DRB Application No.: <u>06DRB-00222 (SBP)</u>	Project # <u>1004709</u>
Project Name: <u>JOURNAL CENTER, UNIT 2</u>	
Agent: <u>John Klee Architecture</u>	Phone No: <u>602-323-7441</u>

**3. Project # 1004709**  
06DRB-00222 Major-SiteDev Plan BldPermit

JOHN KLEE ARCHITECTURE agent(s) for THREE AM, LLC request(s) the above action(s) for all or a portion of Lot(s) 2, Phase 2, **JOURNAL CENTER, UNIT 2**, zoned IP, located on WASHINGTON NE, between RUTLEDGE NE and WOLCOTT NE containing approximately 1 acre(s).  
(D-17)

**Project # 1004709**  
06DRB-00222 Major-SiteDev Plan BldPermit

A-1

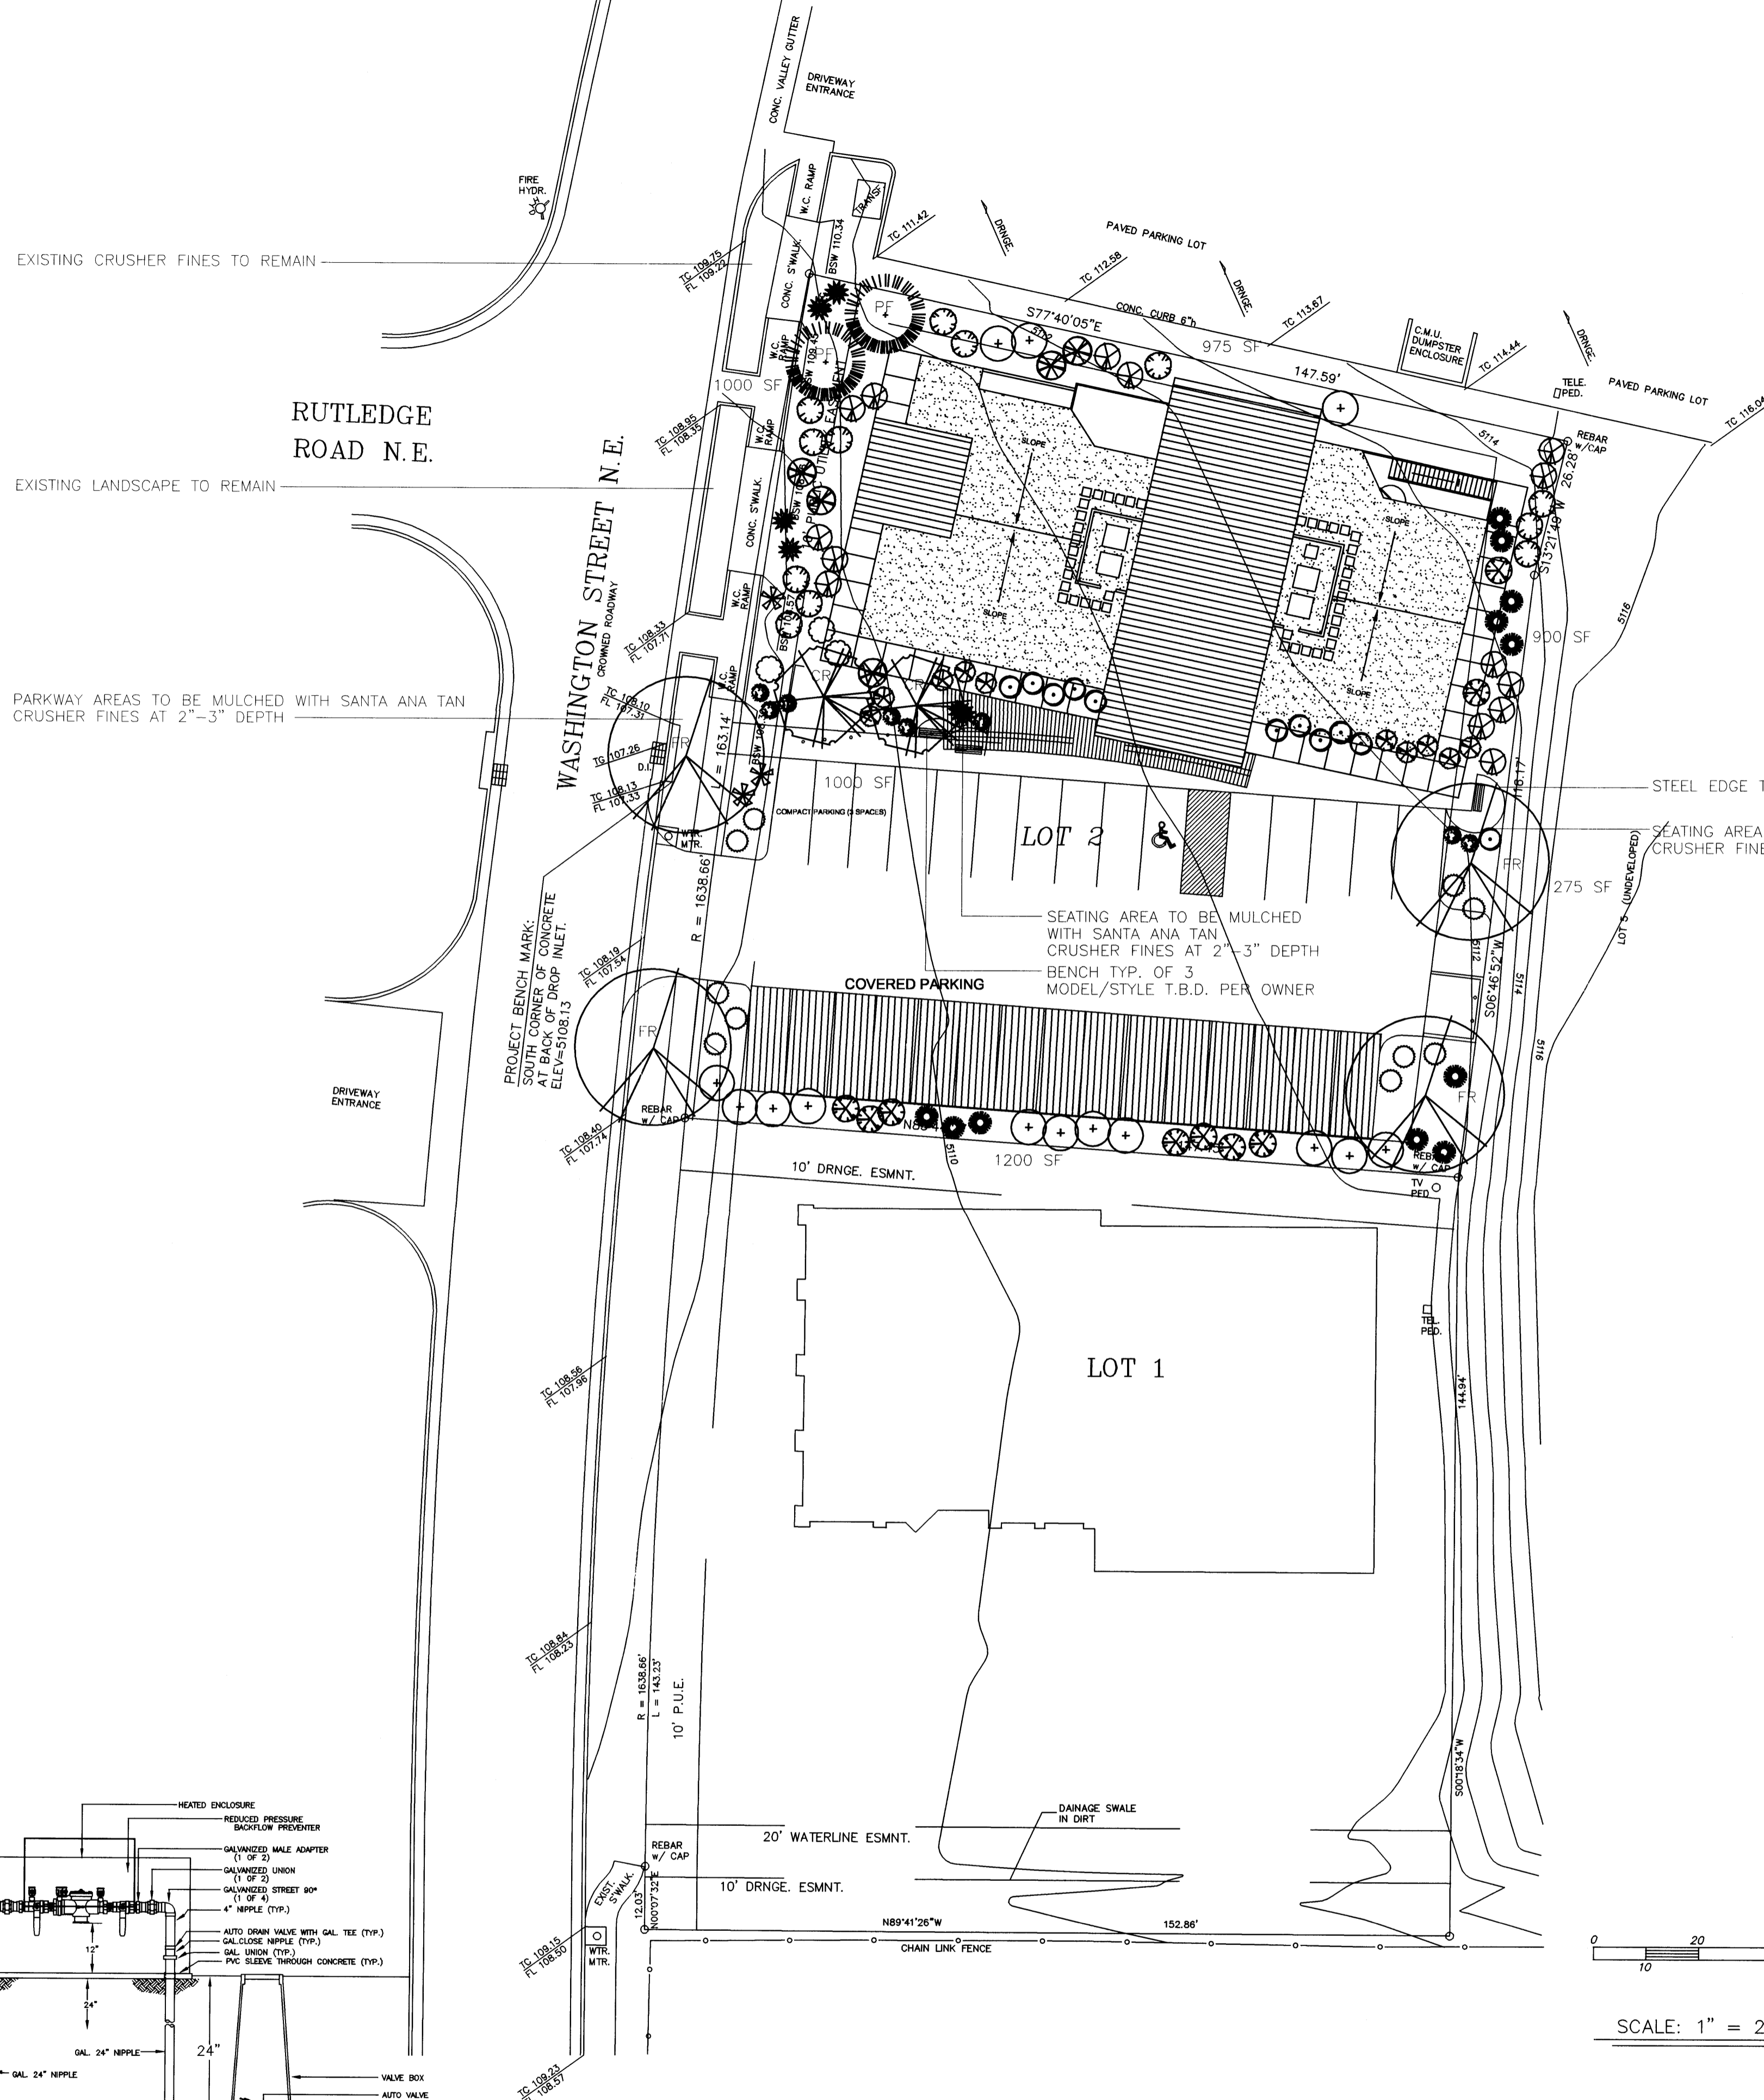
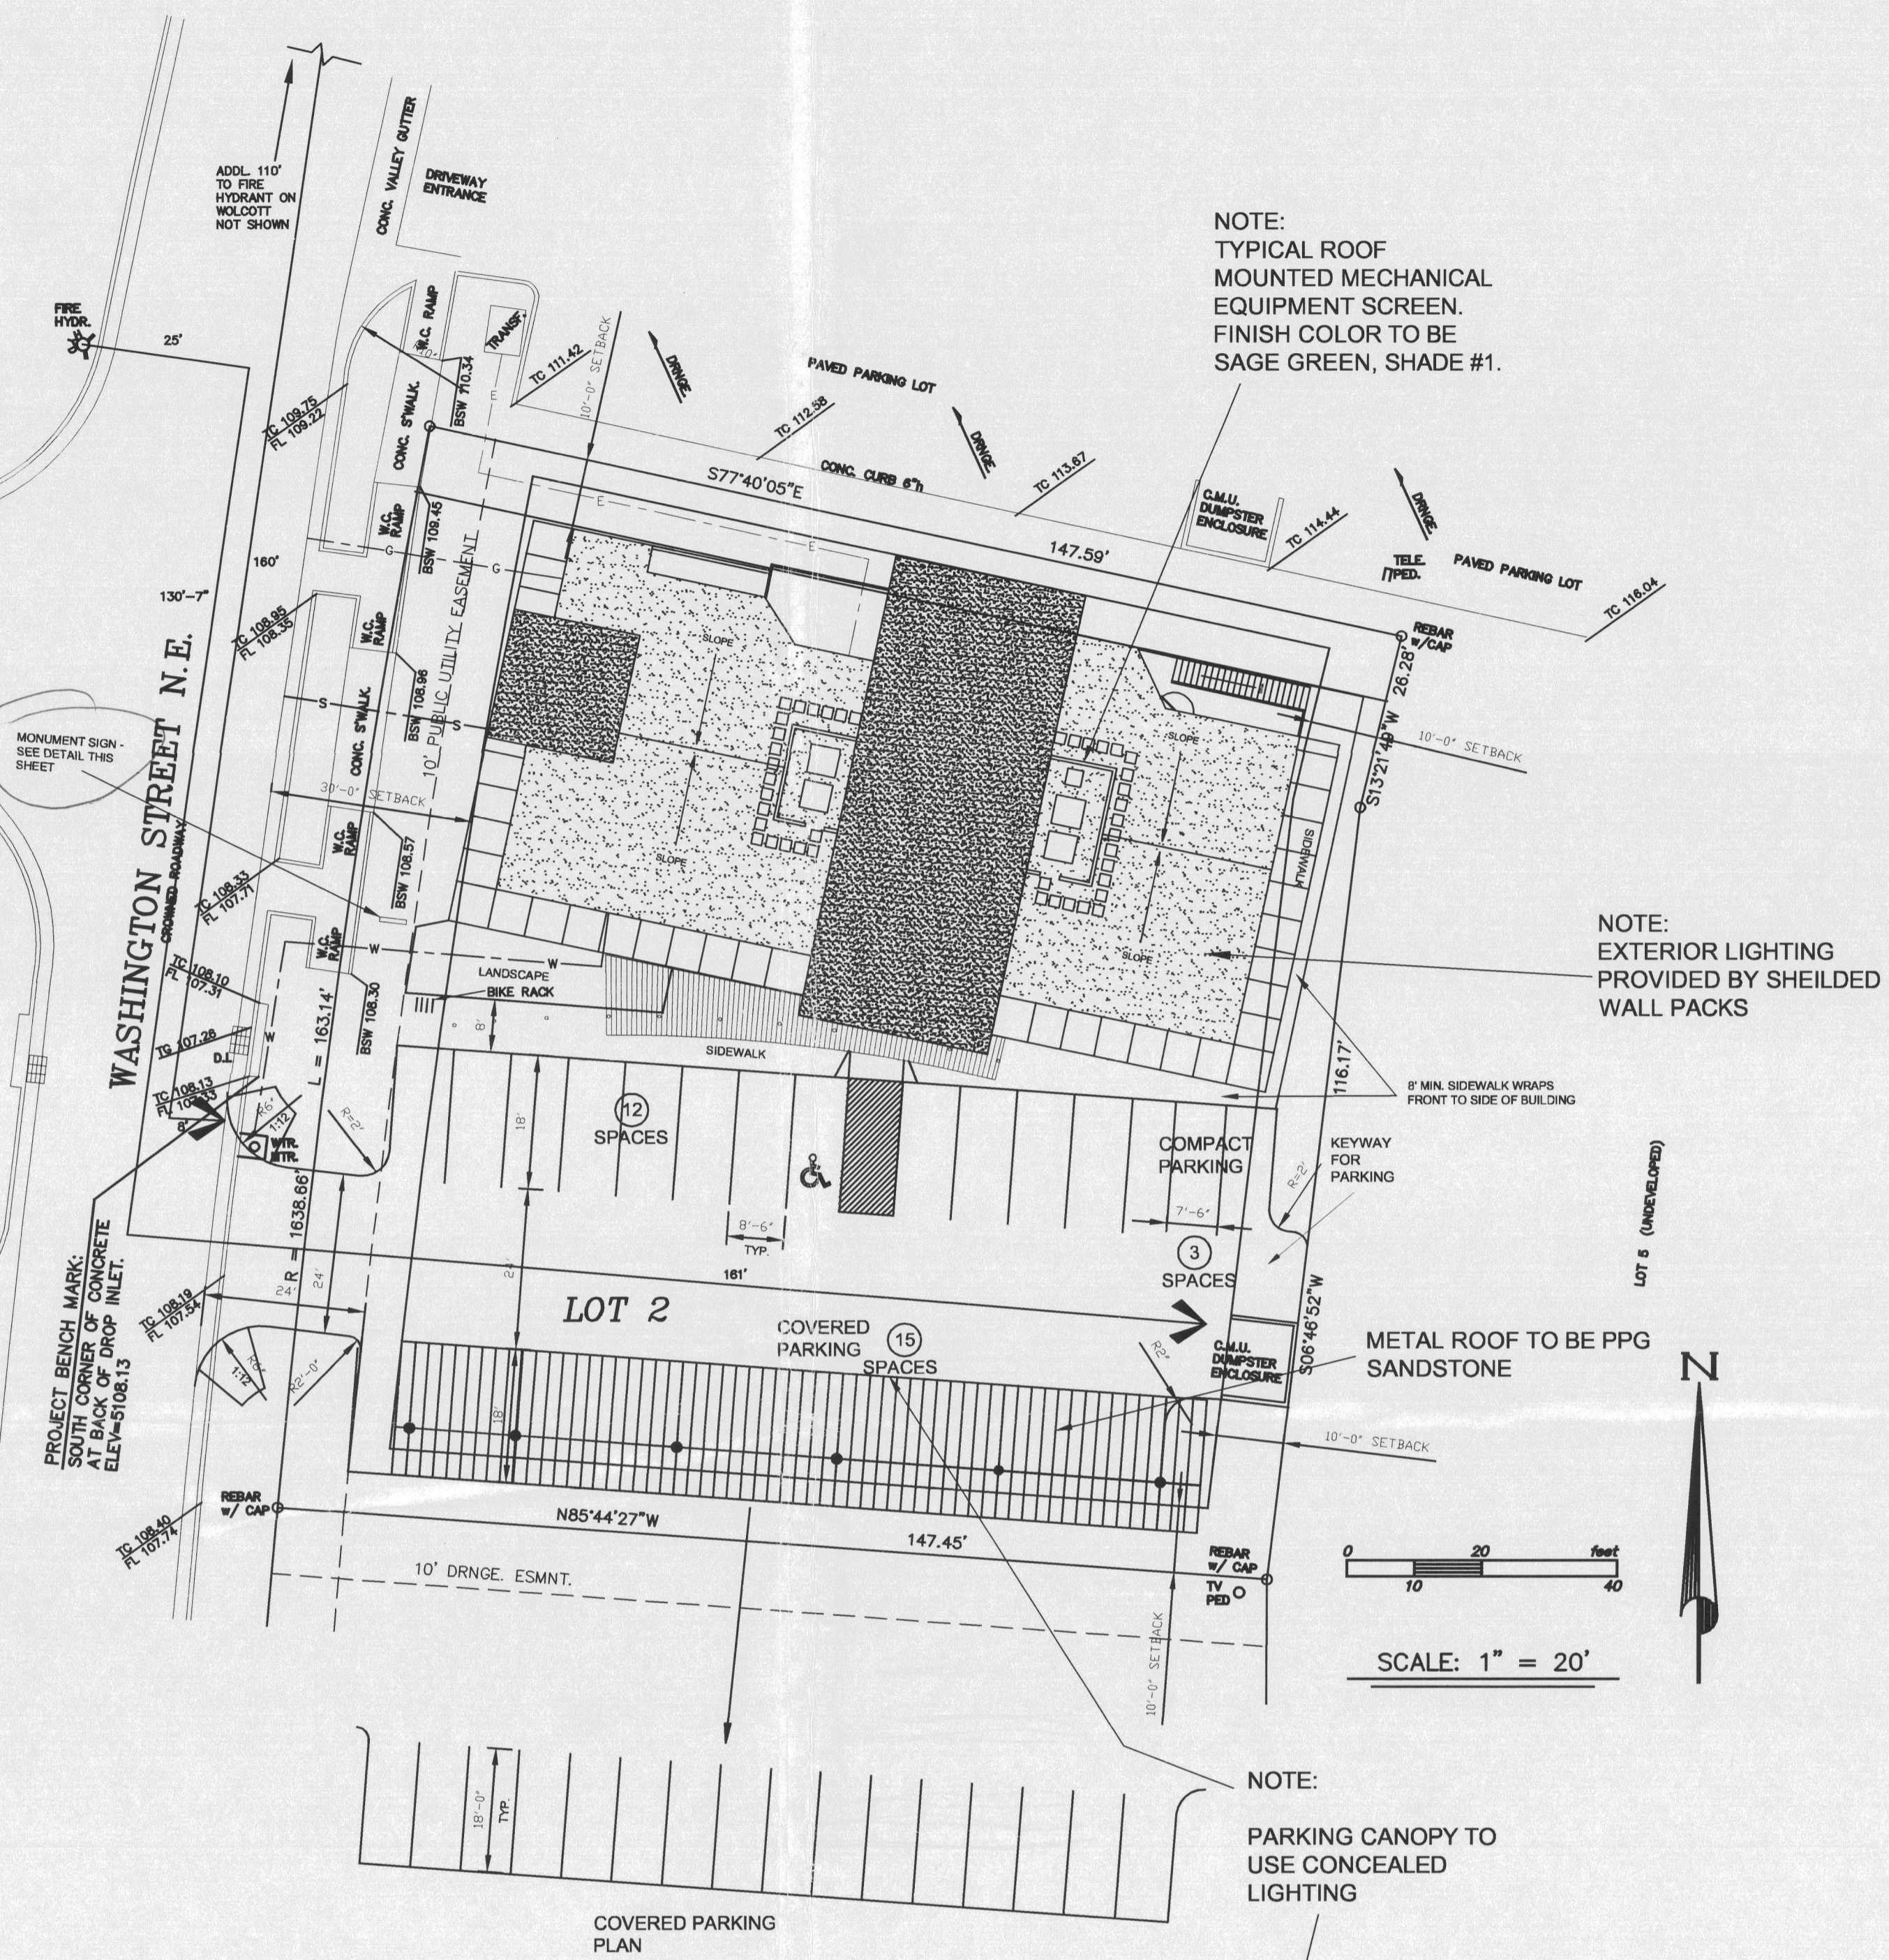
✓ 2. The scaled vicinity map is missing from Sheet A1.

3. Proposed use of the structure is not listed on Sheet A1.

✓ 6. Where is the location of the monument sign ?

Why isn't the site plan reversed? Unsure if the driveway meets offset requirements per the DPM. The landscaping plan needs to ensure sight distance can be met at the driveway. This office is not located on a bus route. Compact spaces are 8' wide. Radii should be a min. of 15'. Where are the build notes for the sidewalk and drive entrance? Are the ADA ramps in place?

1. Planning needs a copy of the Journal Center 2 ARC's approval letter. Otherwise, a much more detailed review of the site plan is required by Planning.
2. Proposed use of the structure is not listed on Sheet A1.
3. Sight lighting? Height & type.
4. The material and colors of building structures.
